**WEST SUSSEX COUNTY COUNCIL
PLANNING SERVICES CONSULTATION**

SUBJECT: WA/69/17- Variation of condition 2 imposed under WA/29/17/RES relating to approved plans (relocation of plots 5 & 6).

Progress Garage, Yapton Lane, Walberton, West Sussex, BN18 0AS

plots 5 and 6 - floor plans

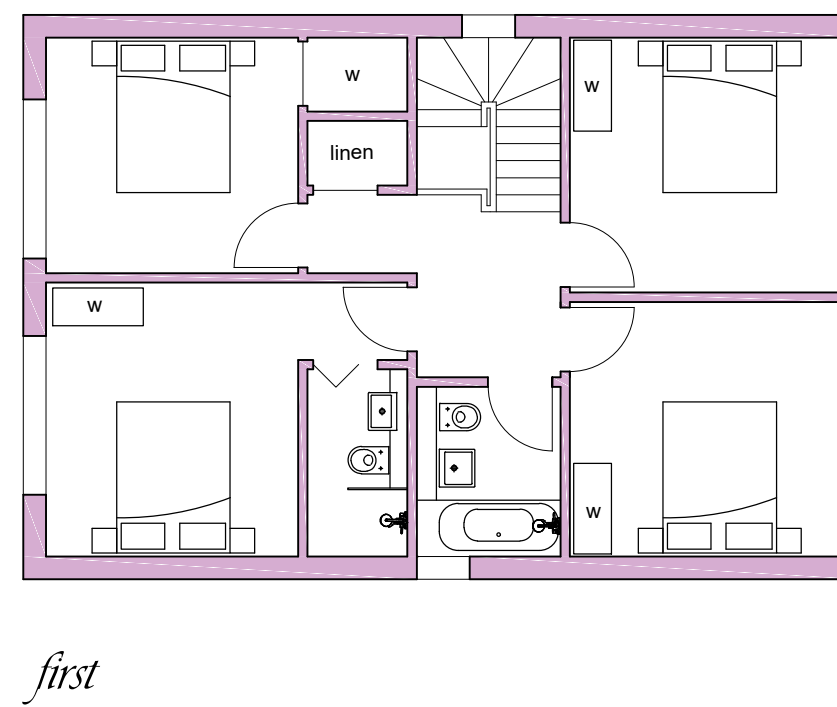
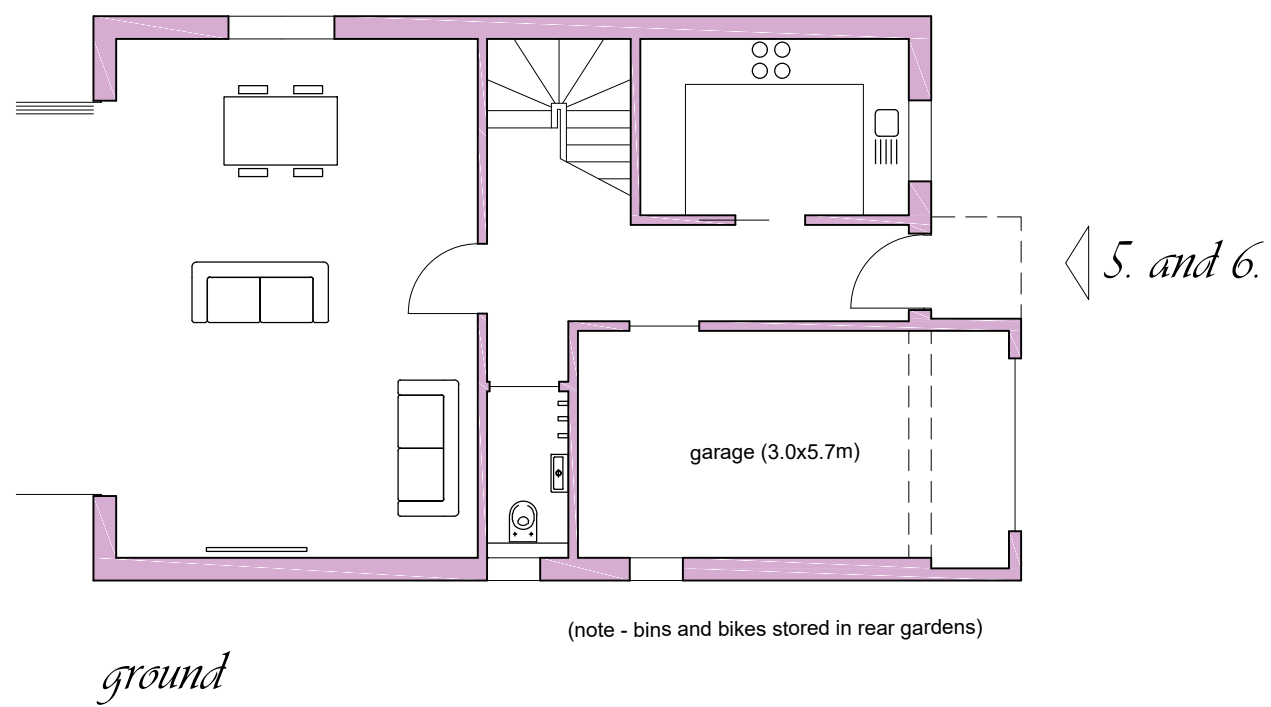
The proposal is to move plots 5 and 6 600mm east. This reduces the hardstanding designated for car parking from 5.40m to 4.8m.

WSCC standards for a parking space are 2.4m x 4.8m, this amendment would see vehicles use the entire length of hardstanding to allow a vehicle to park.

Although this does not pose a severe highways safety concern, the Local Planning Authority (LPA) may wish to consider this from an amenity perspective, in that vehicles will be encouraged to park in close proximity to the front door of the dwellings. This is especially relevant for plot 6 which has a smaller area of hardstanding width.

Based on the information provided, the LHA would raise no objections to the proposal, access and turning are unaffected by this proposal and remain as agreed previously by the LHA.
